Report following a request for further information, negotiations or consultation

REF NO: P/155/21/RES

LOCATION: Land West of Pagham Road
Pagham

PROPOSAL: Approval of reserved matters (layout, scale, appearance and landscaping) following outline consent P/140/16/OUT for the 'local centre' parcel which comprises of retail, community and commercial uses, 20 No residential apartments and a 70 bed care home.

TITLE:
SPINE ROAD AND
LOCAL CENTRE ACCESS

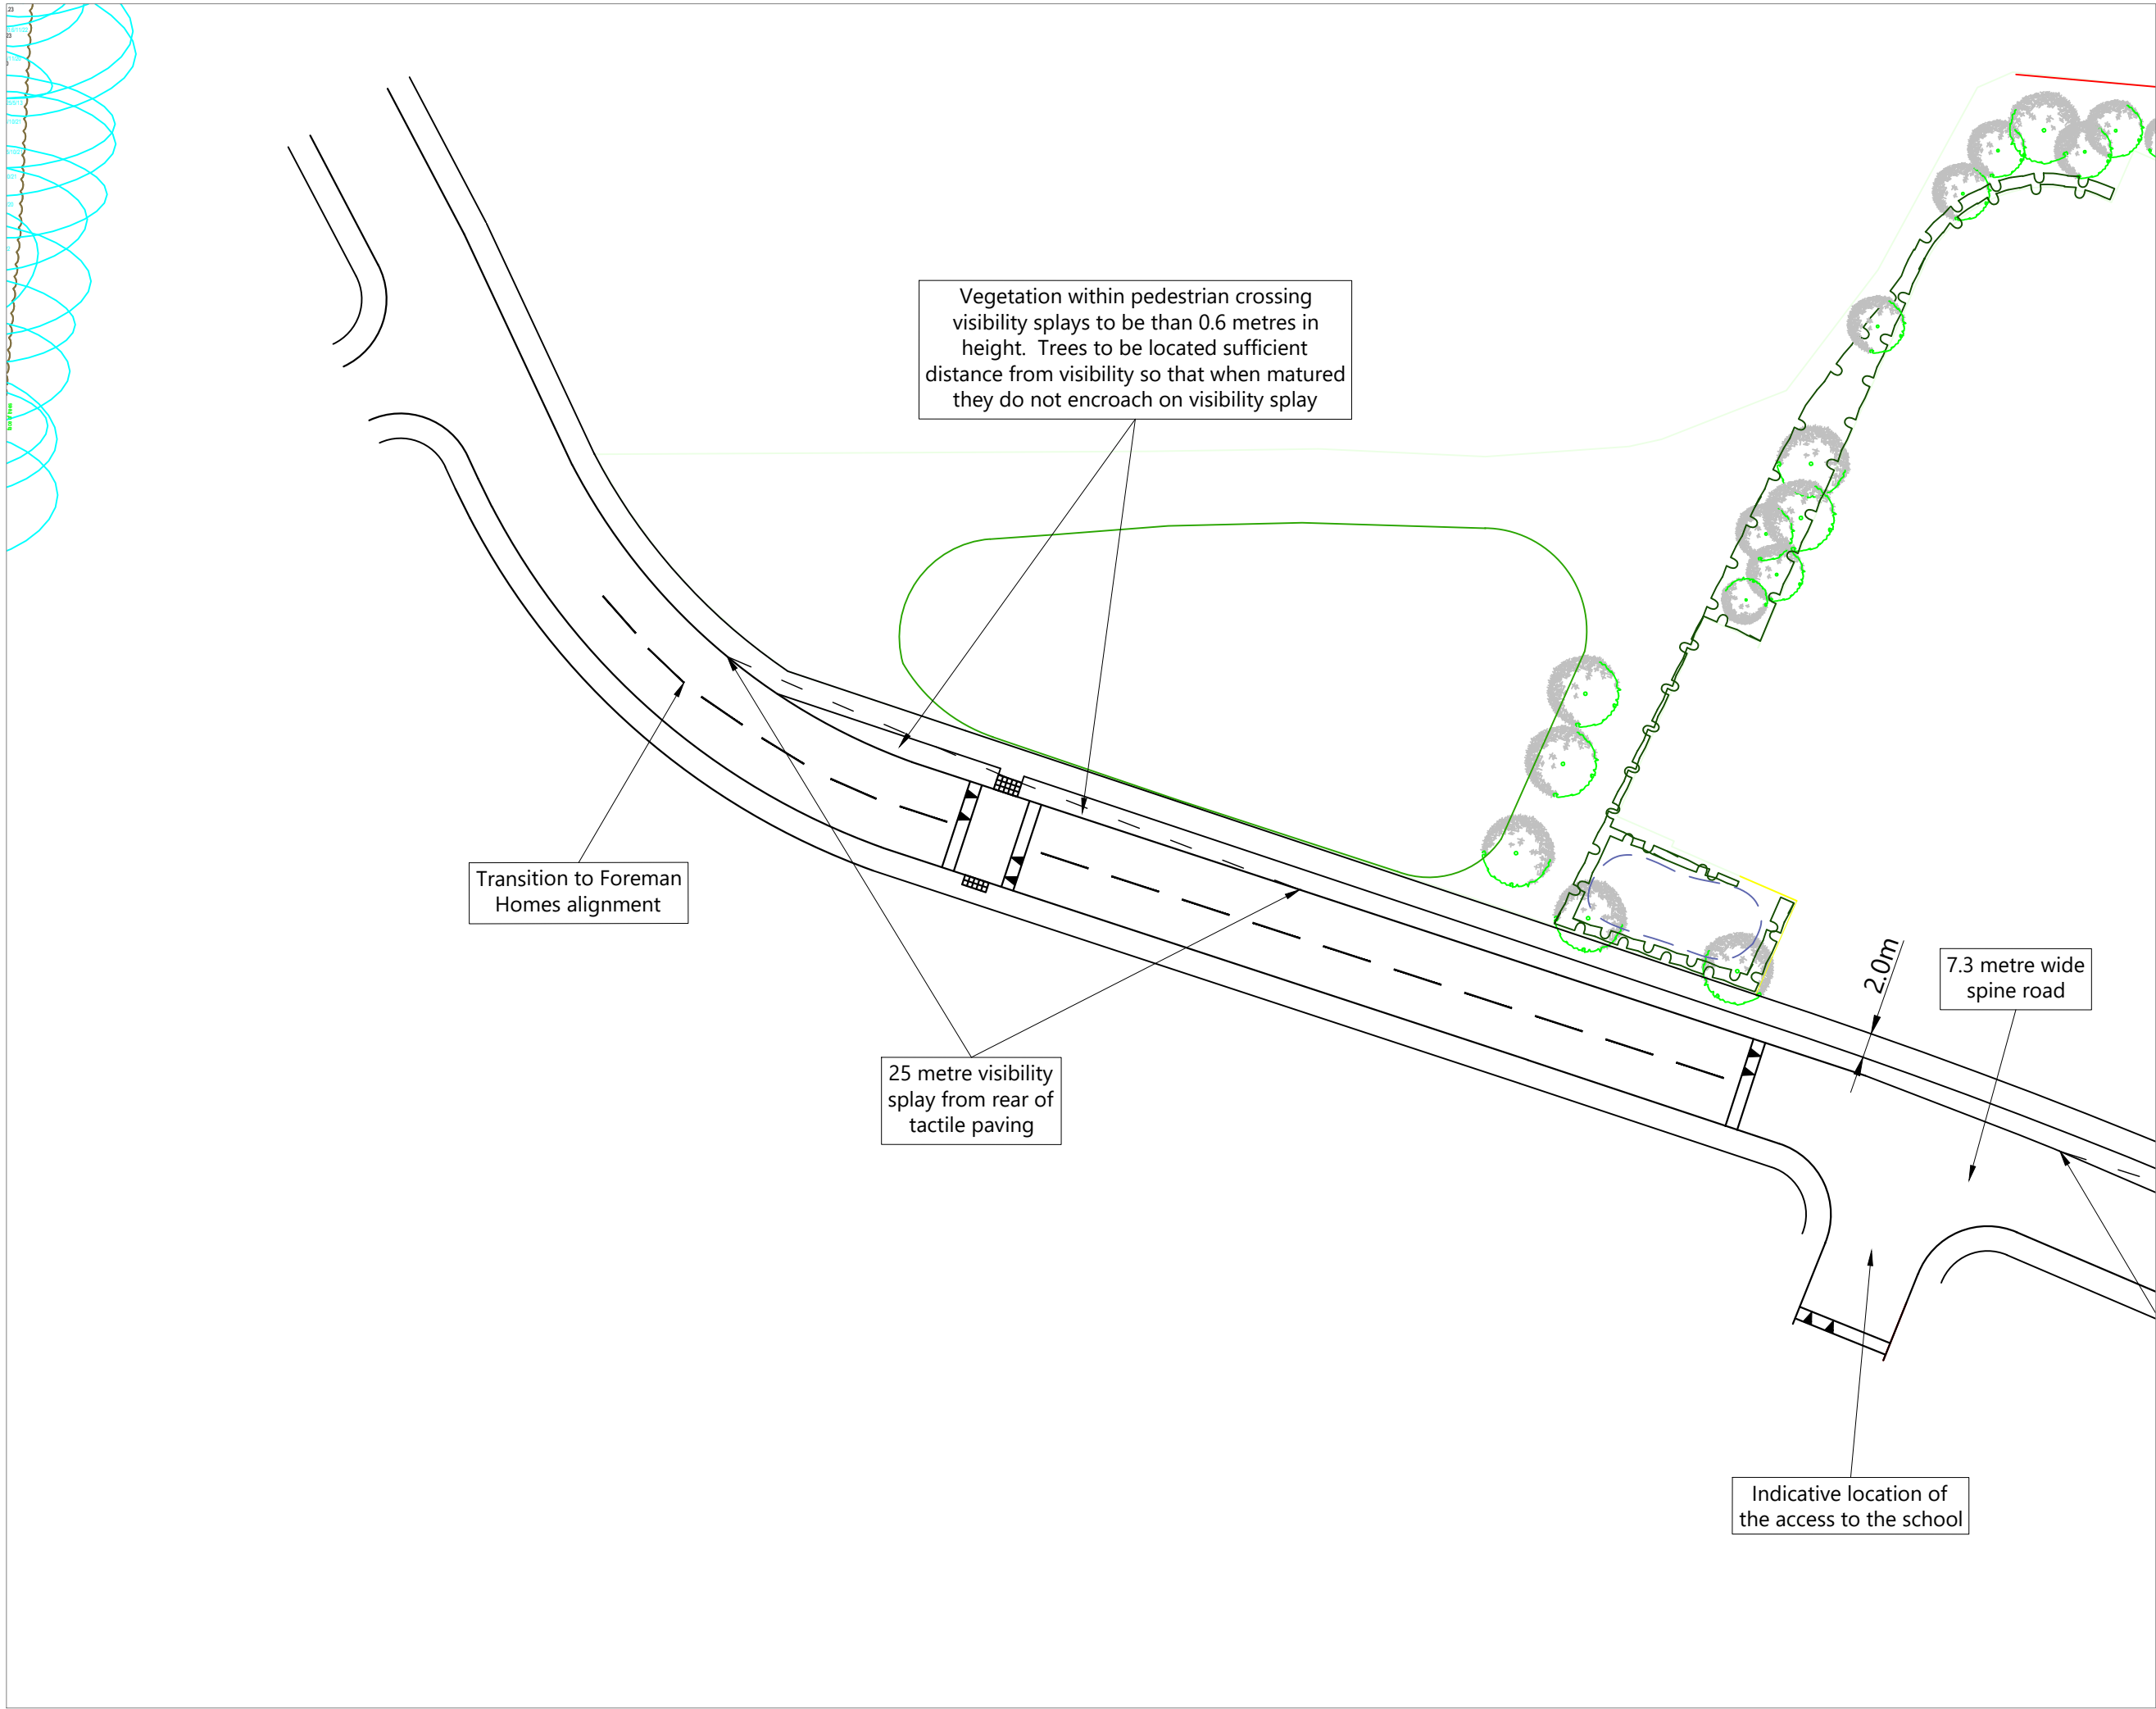
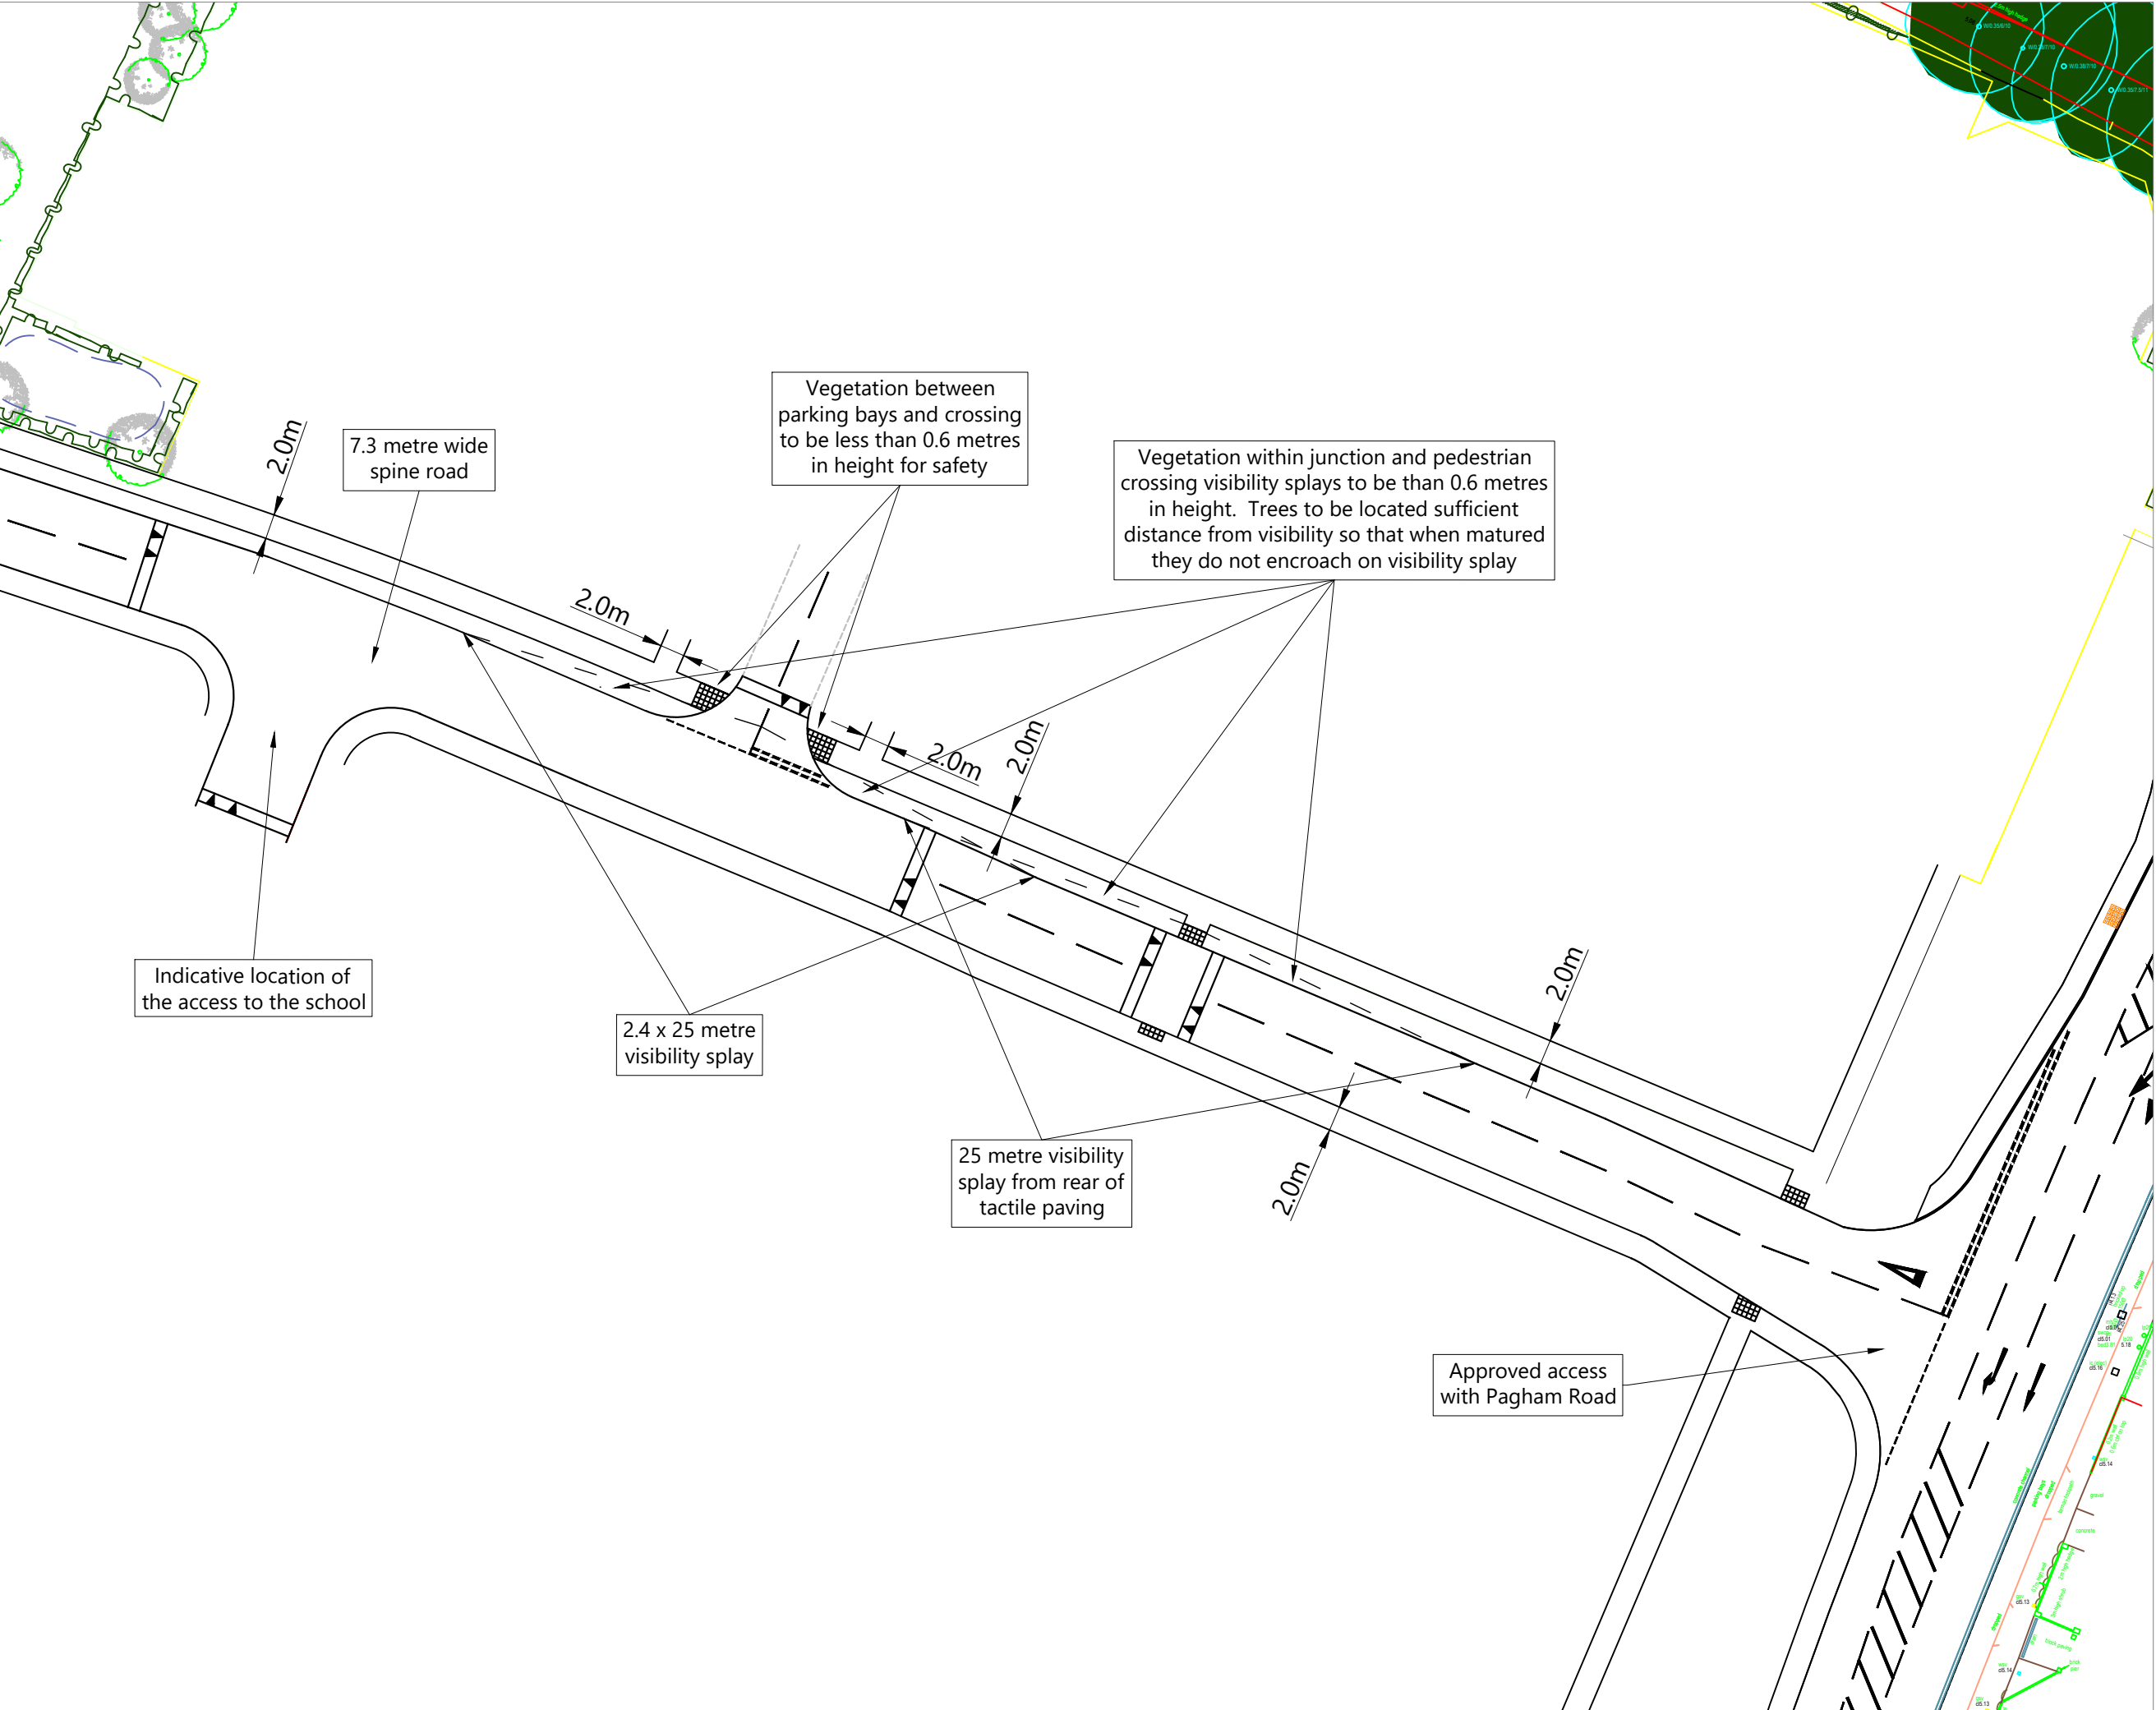
- the Council would like to see a wider road. This does not allow for vehicles to easily pass.

- The spine road will measure 7.3m in width, with the roads within the local centre measuring approximately 6m in width. These are more than sufficient for the scale of development proposed.
